RFI

RFI #: 47
Date: 1/30/2012
Job: EB-02 Keller Springs Lofts
Phone: 877-777-5115

Subject: Shear wall hold down/ anchorage

Subject: Substitution option for sill plate anchors

**S2.36**

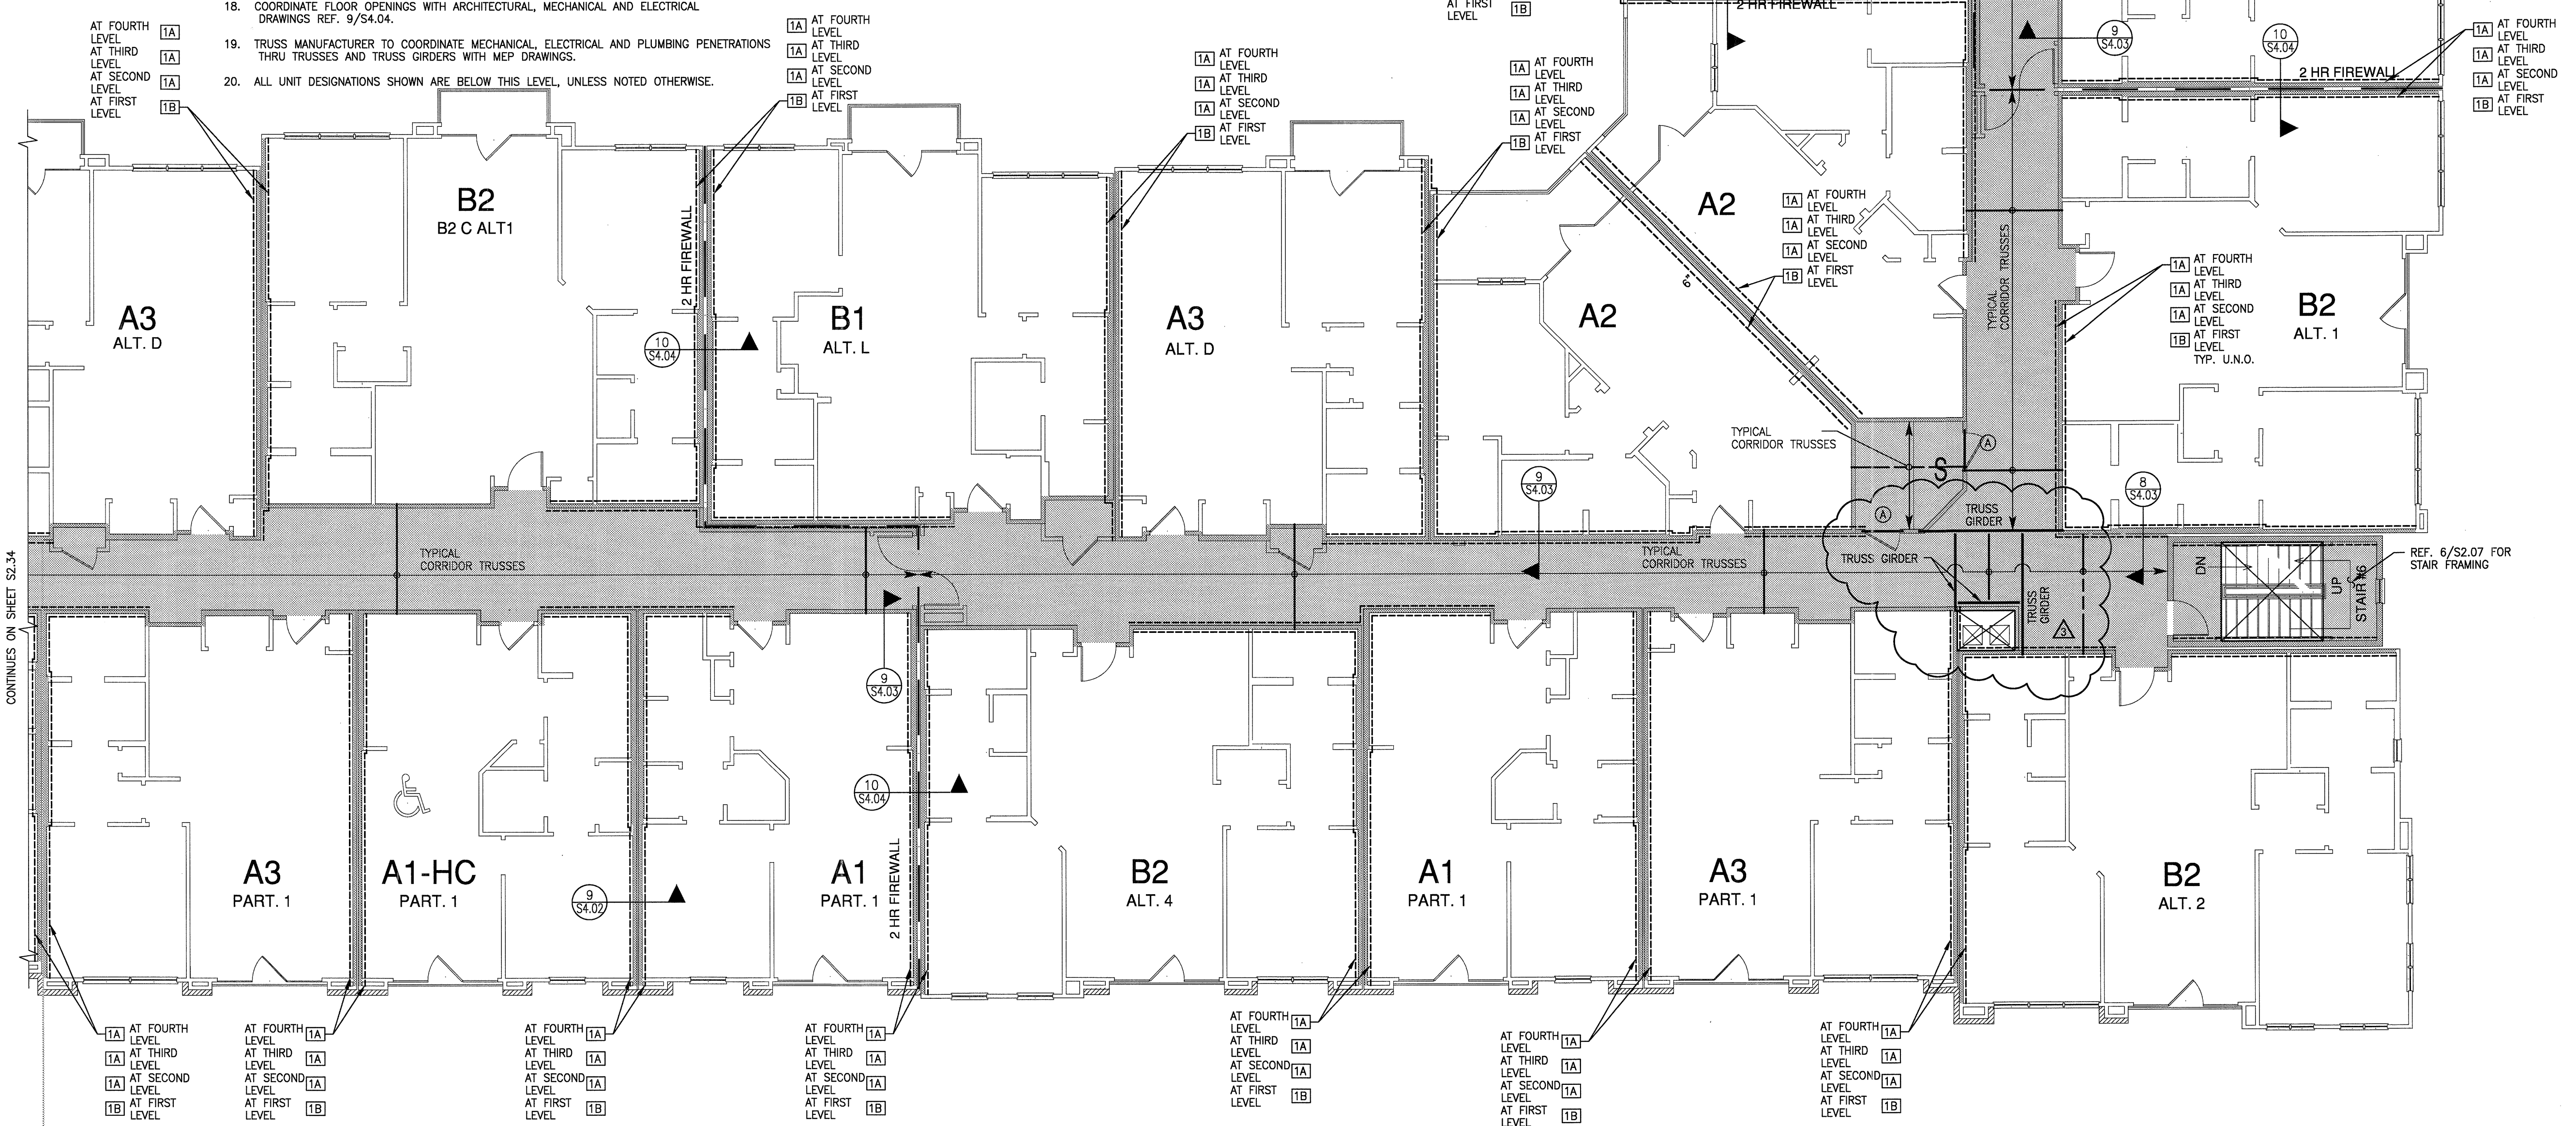
Request: Date Required: 2/6/2012
Trent, Makerick framing our framing subcontractor has an RFI. We have reviewed the structural plans and have a question concerning the shear wall hold down/ anchorage. Pages S2.31 through S2.36 gives us shear wall types and locations for the different floor levels. The plans tell us that the first floor shear walls are type 1B. The 2nd, 3rd, and 4th floors are type 1A. Detail 5/S1.0 (shear wall schedule) tells us what the wall board application is and its nailing pattern. It also tells us what type of intermediate wall anchorage will be used. We do not see where any end wall anchorage (detail 6/S1.03) is called out. Is there any end wall anchorage? Are we missing something?

No. Based on our review of the drawings, no endwall anchorages are required.
